**Consultation Response from KC,  
Highways Development Management**

**2024/93189 Unit 19-20, Headfield Mills, Savile Road, Savile Town, Dewsbury, WF12 9LQ**

**Erection of single storey extension, external alterations to shopfront to front and side elevation, change of use of part vacant area into class E Cafe and formation of car park access**

**Date Responded: 10-6-2025.**

Drawn by	Date	App'd	
AM	02/24	-	
Drawing no	Project no	Scale @ A3	Rev
PL-01	23-918	1:200	-

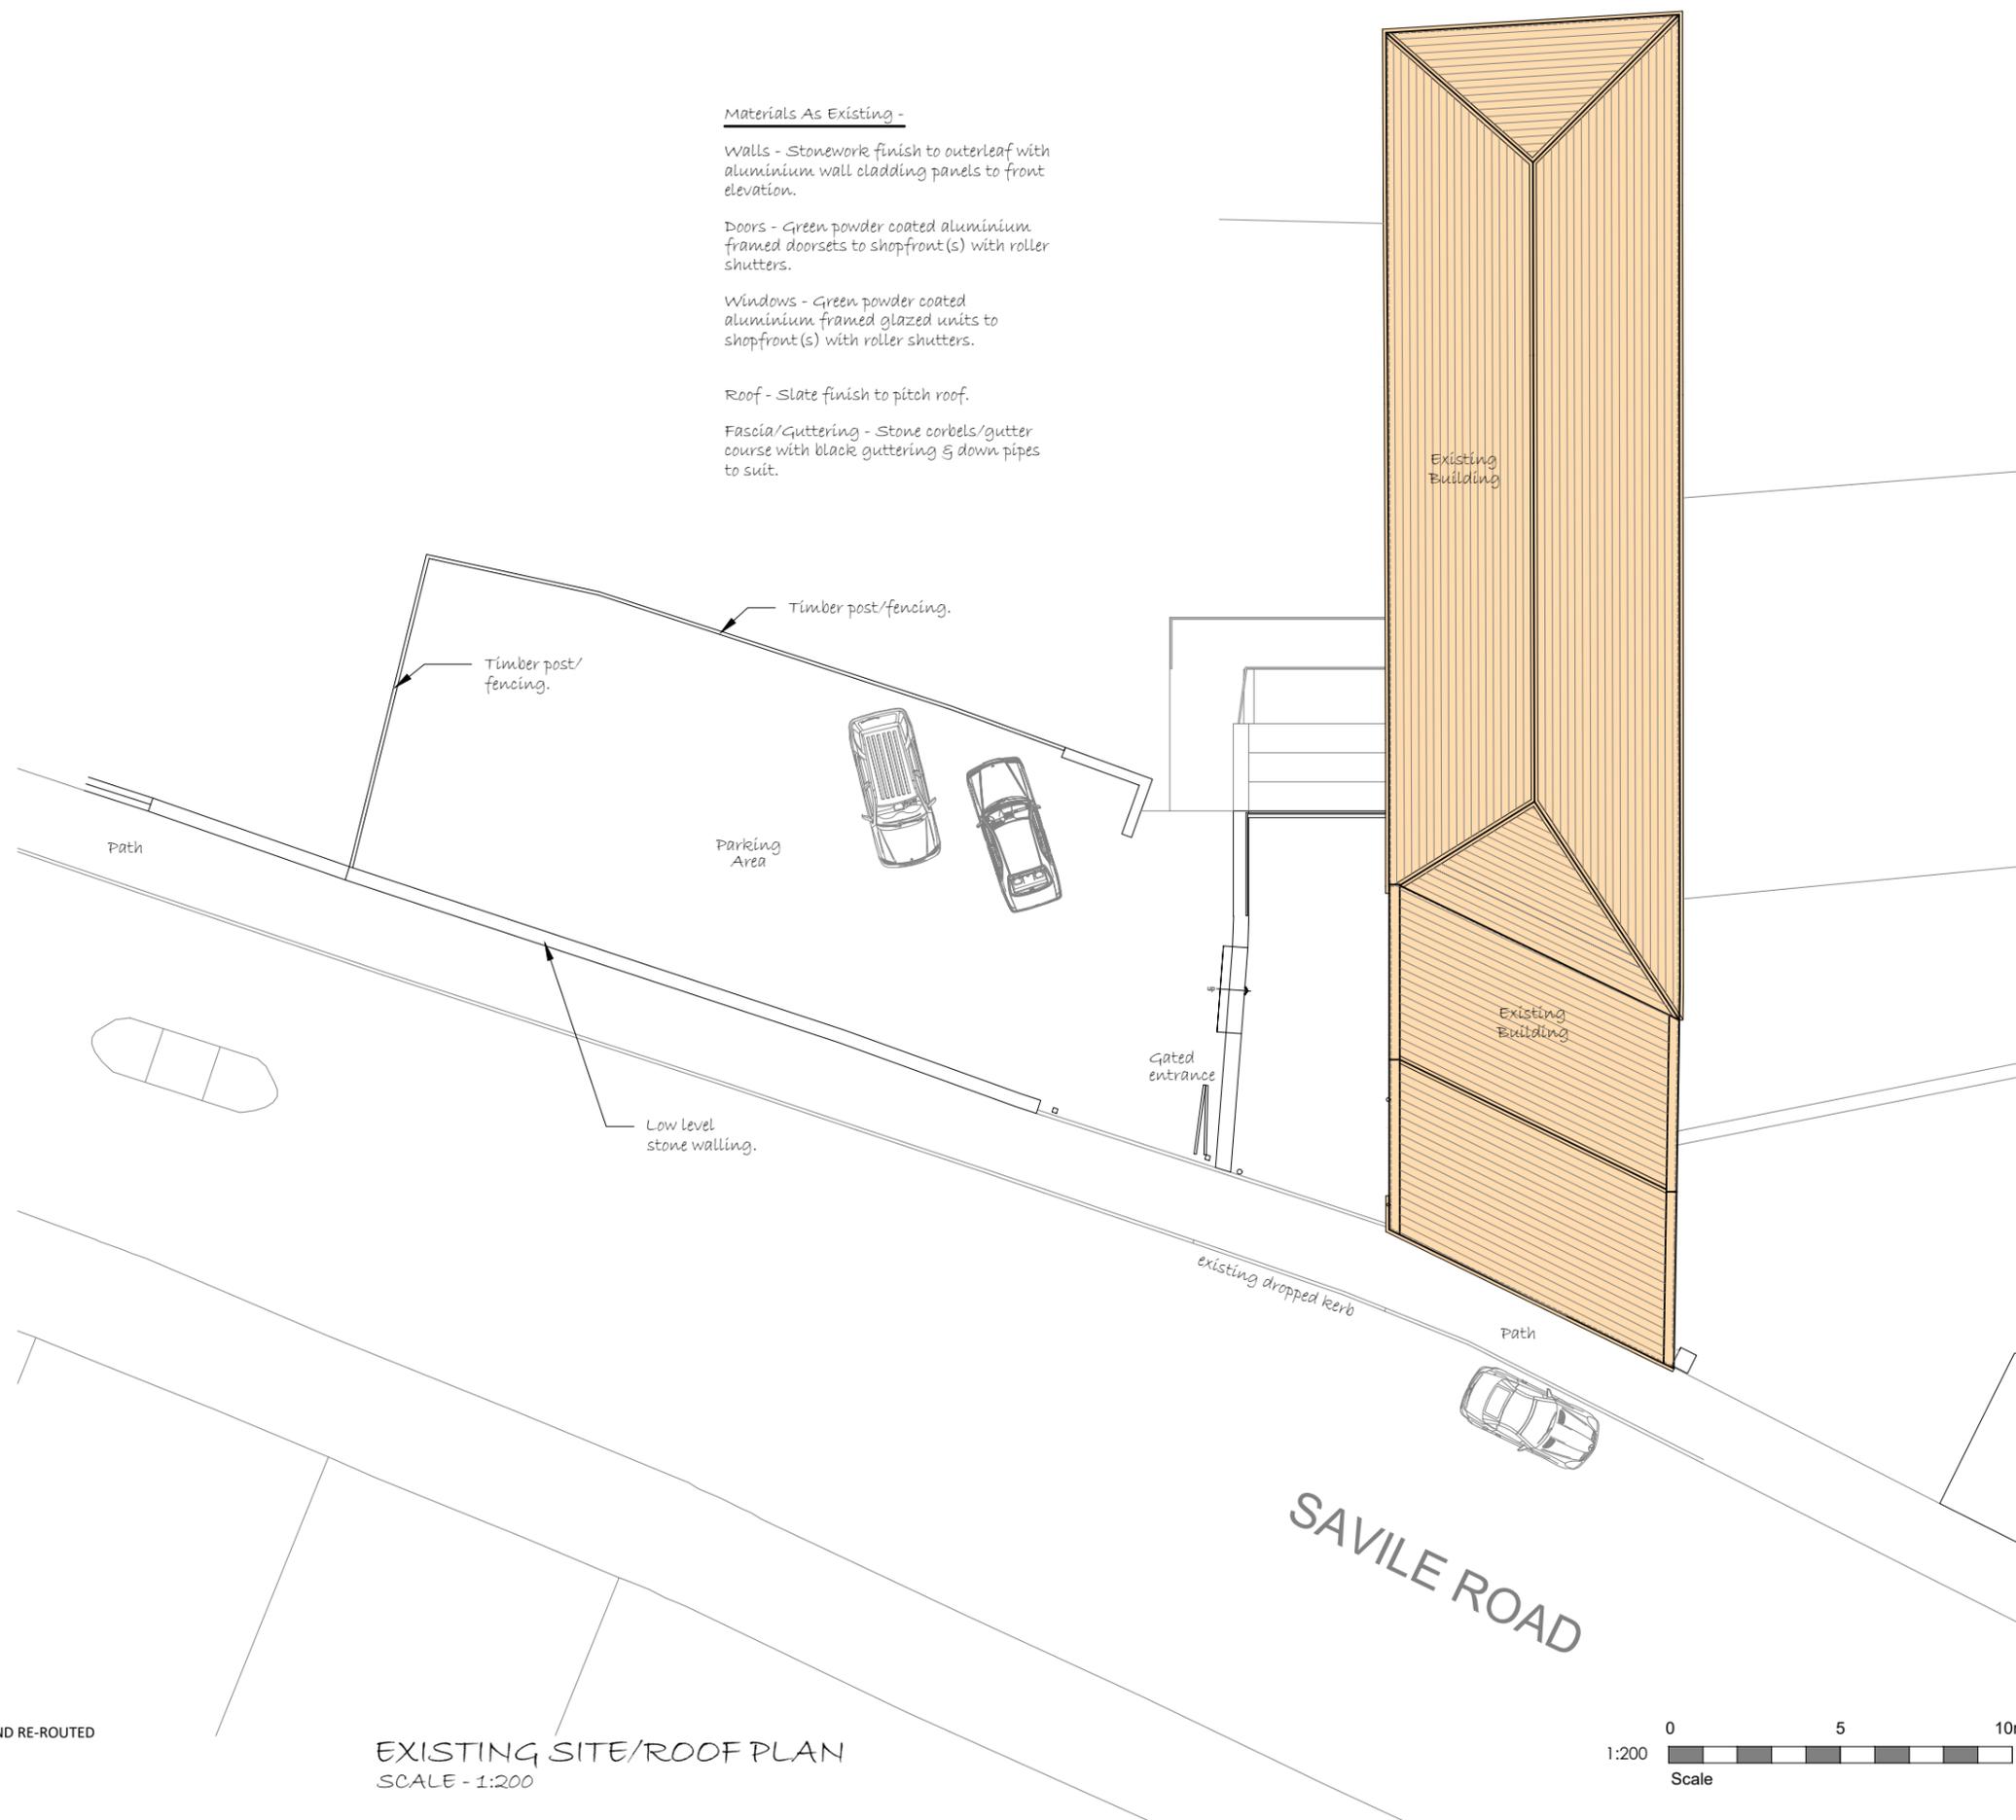
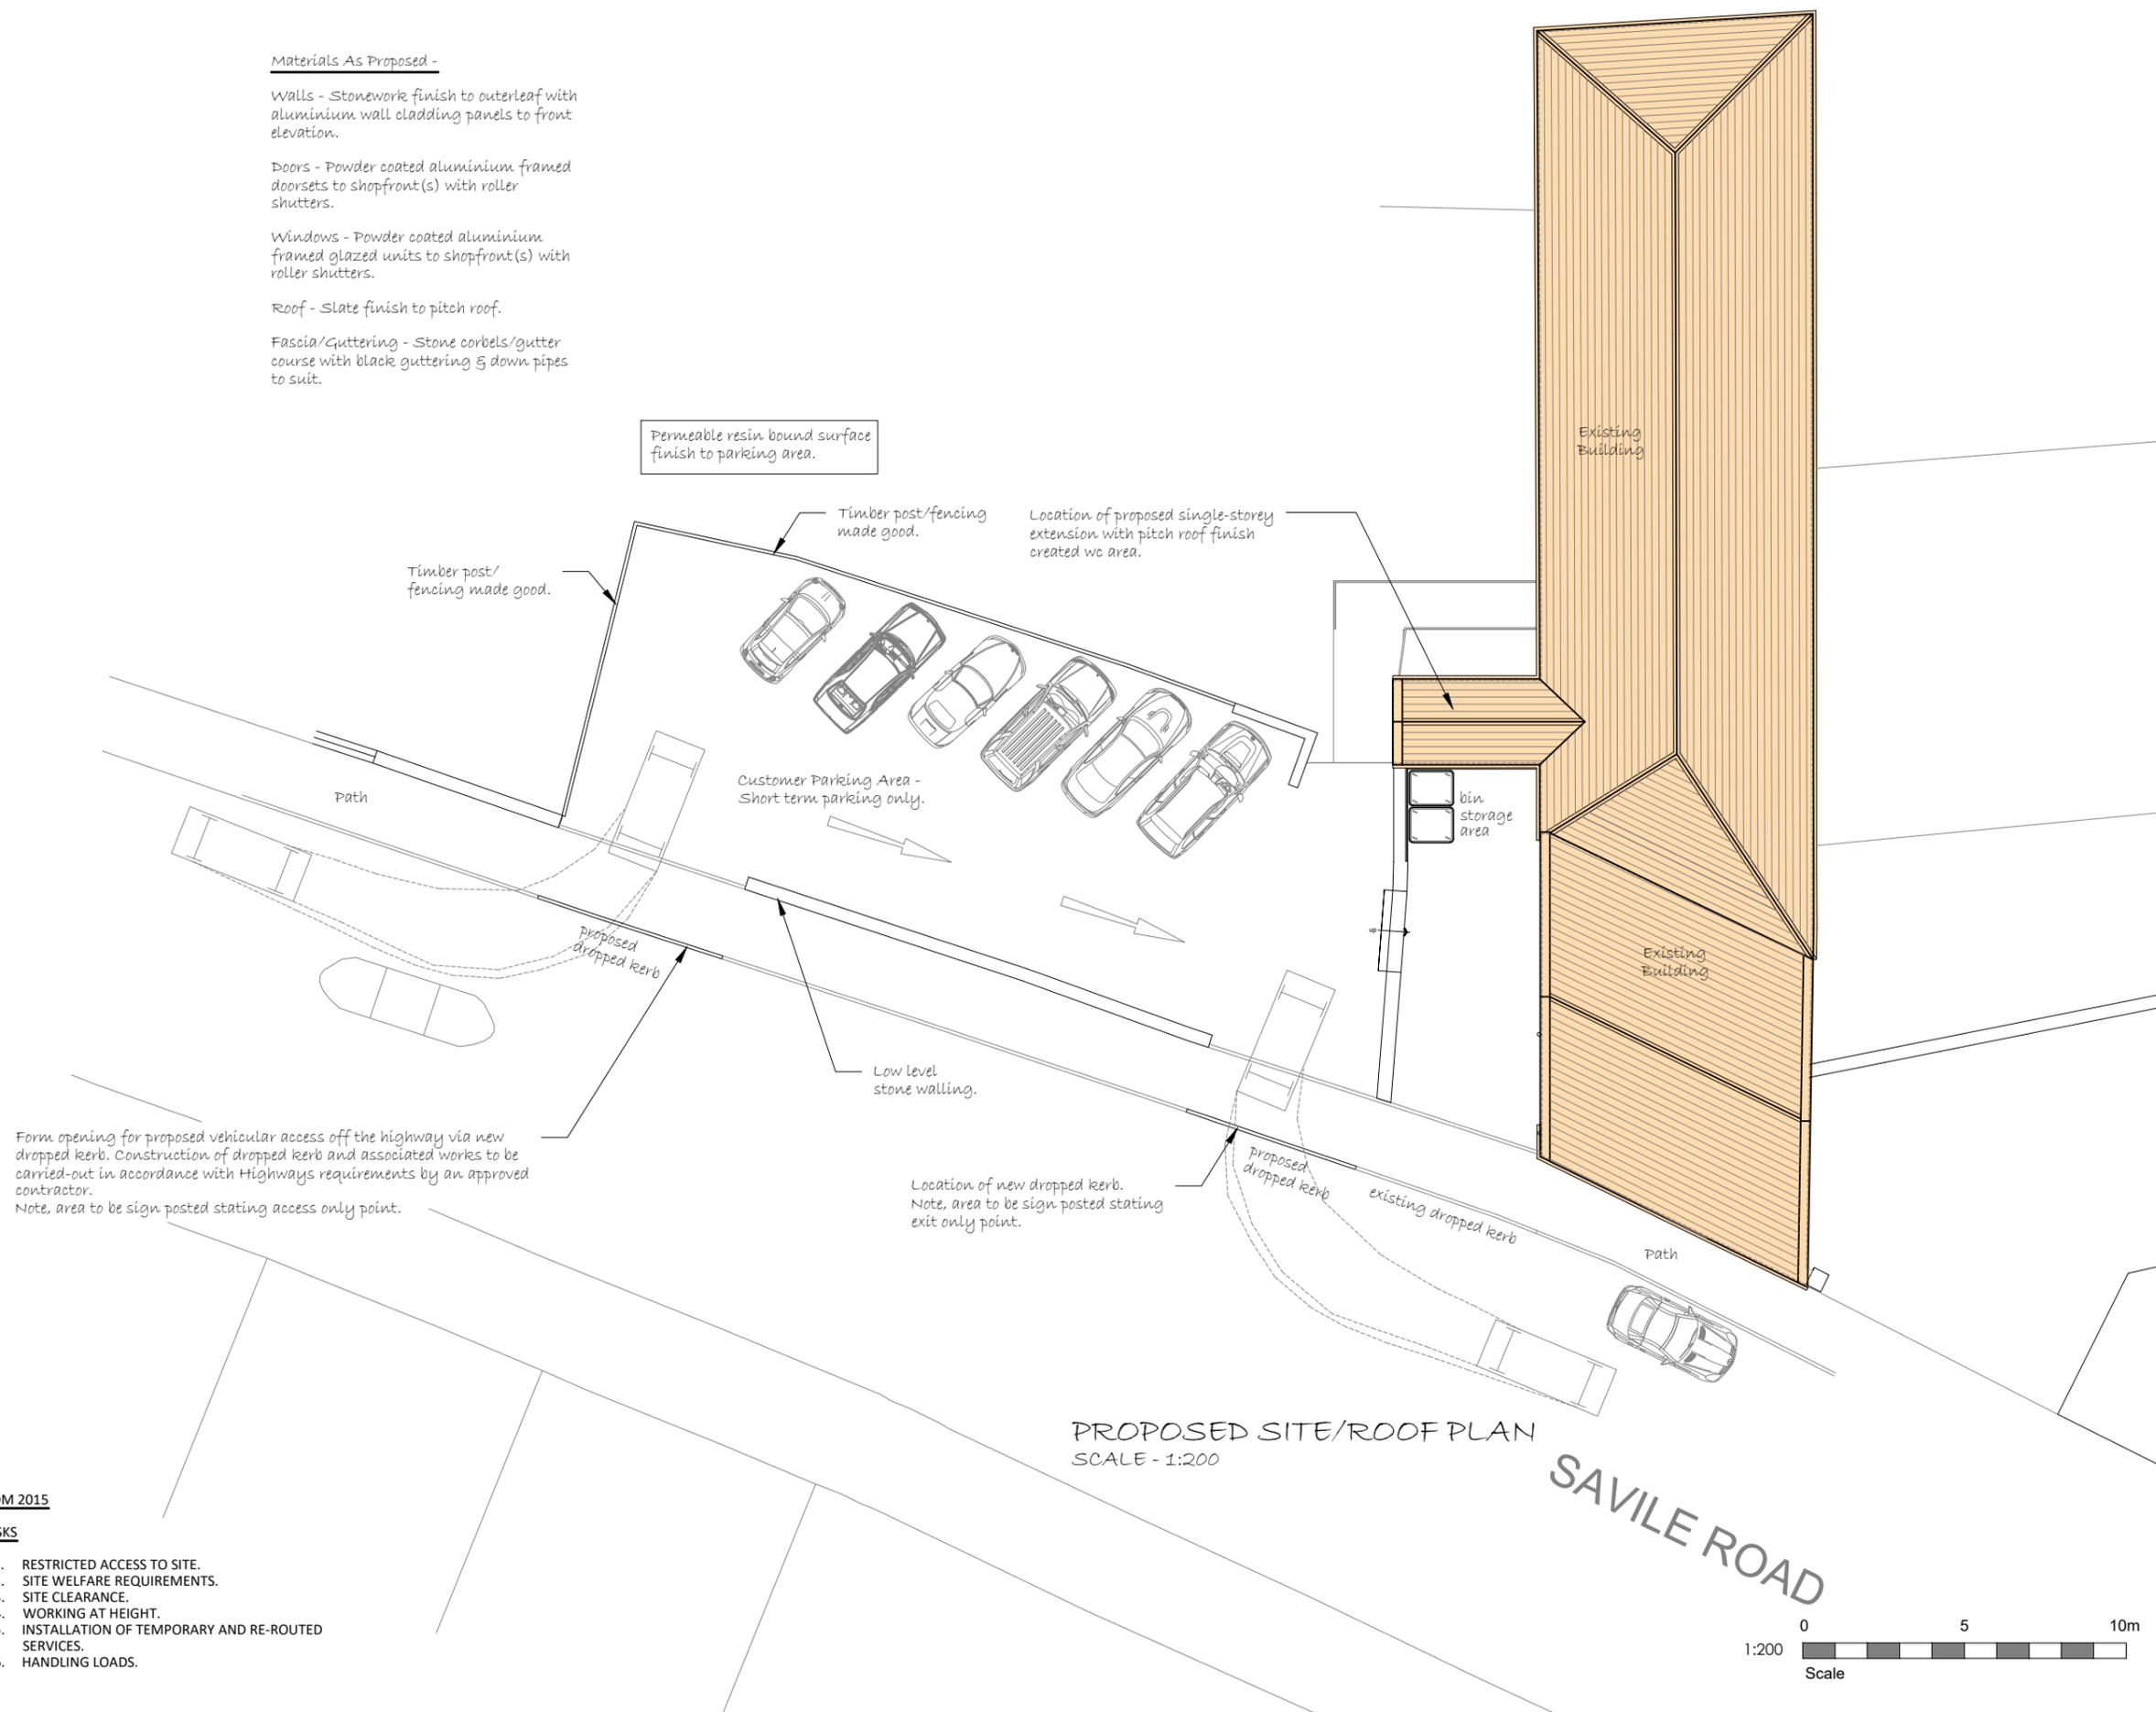
The proposed Site Plan PL01 and Floor Plan PL02 show a small extension for a proposed customer toilet, internal changes to create a lobby, kitchen, servery and seating for a small café and staff facilities within a loft space.

A proposed customer car park is shown with two proposed accesses onto Saville Road. An existing access to the north and a proposed new access to the south.

The layout of the proposed car park is not properly shown on the plans. A proper parking layout should be provided with the parking bays, access road and accesses from Saville Road dimensioned. Details of the proposed construction should also be provided. 8 spaces may be possible only 6 vehicles are shown.

The swept paths show the turning movement of a vehicle into the southern access and out of the northern access. The applicants should clarify their proposals is this to be an IN and Out arrangement or will both accesses be open to all traffic.

The southern access is close to an existing traffic island in Saville Road. Only a swept paths showing the left turn movement in is provided. The right turn inward should also be provided, and the right turn out if this access is to be open to all traffic. Depending upon swept paths this access may need to be widened or the traffic island re-sited.
